Dear Michael,

In relation to the above application, please may EH comment as follows:

TOP SOIL RELOCATION  
 SITE PLAN  
 1744-TS-P02-E

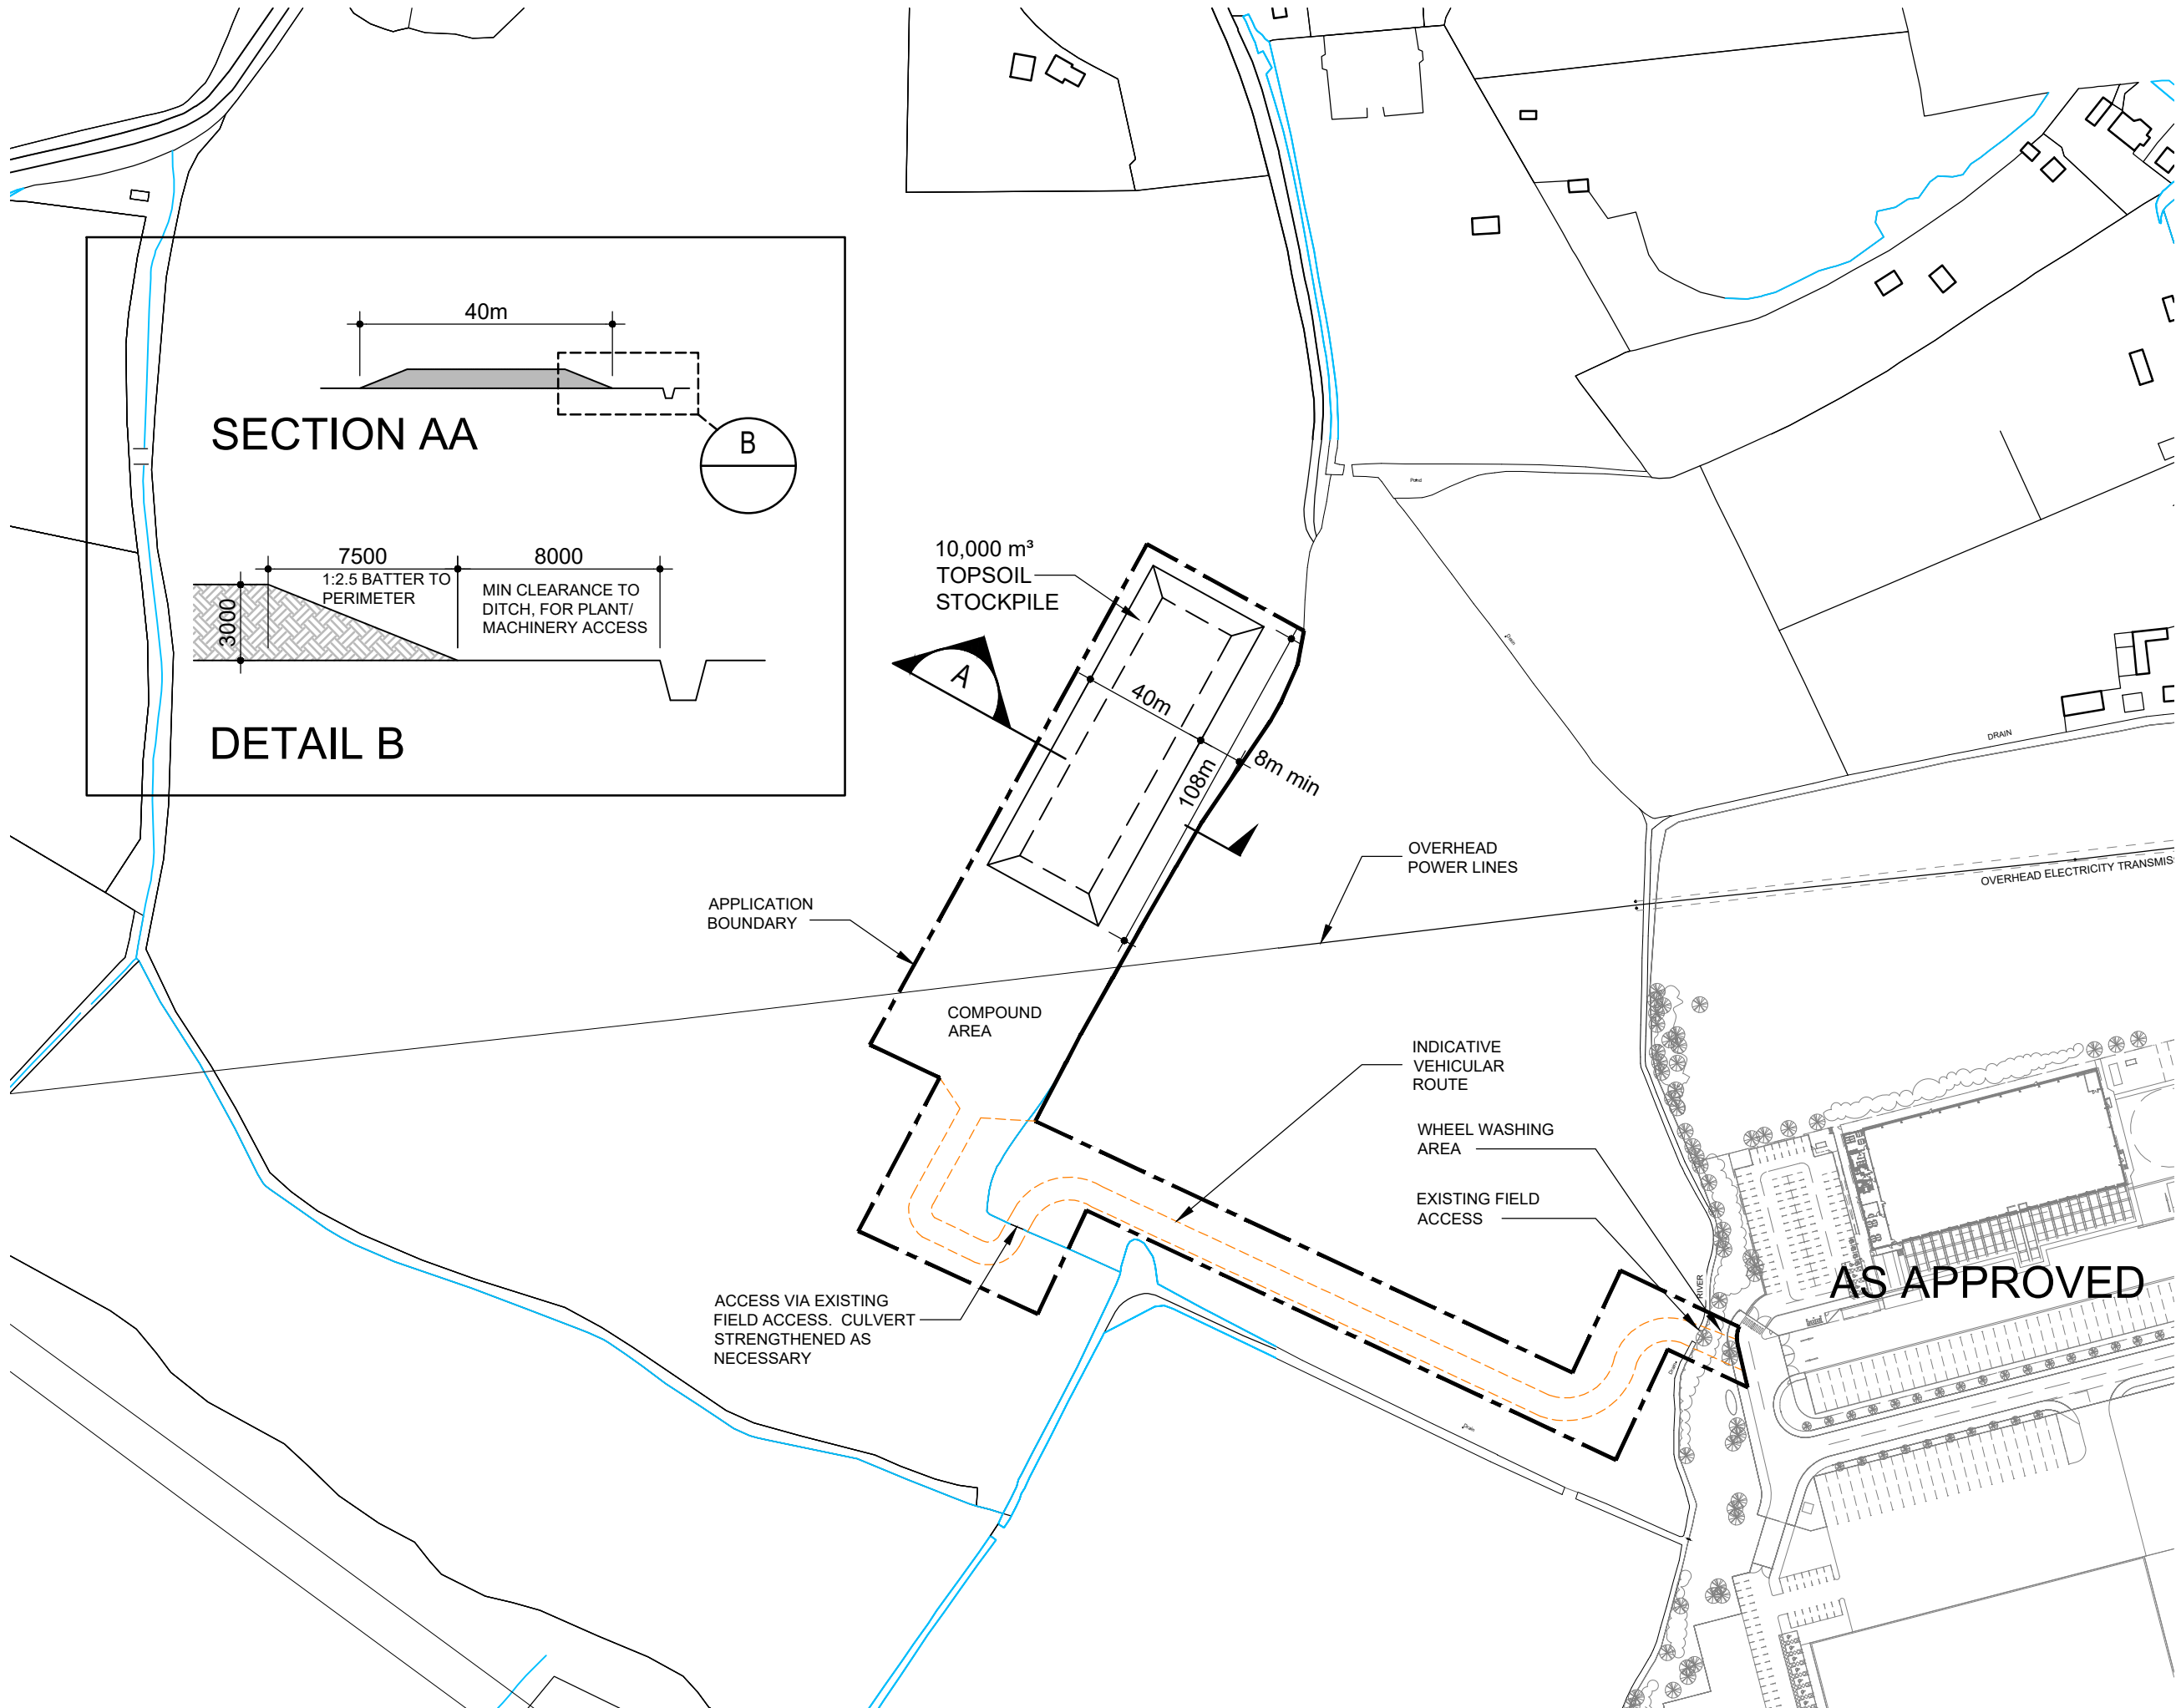
- the application does not include any detail of how dust generation will be minimised. The applicant should therefore provide a dust management plan in relation to potential impact on neighbouring properties, including an assessment of the nearest sensitive receptor(s);
- the proposed bund should be separated from the underlying soil/material (using, for example, a suitable barrier and/or membrane);
- No demolition/construction activities shall take place other than between 08.00 hours and 18.00 hours (Monday to Friday) and 08.00 hours and 13.00 hours (Saturday) with no noisy work on Sunday or Bank/Public Holidays. **Reason:** To protect the amenity of local residents in accordance with Policy QE SP1 of the Adopted Arun Local Plan 2011 – 2031.
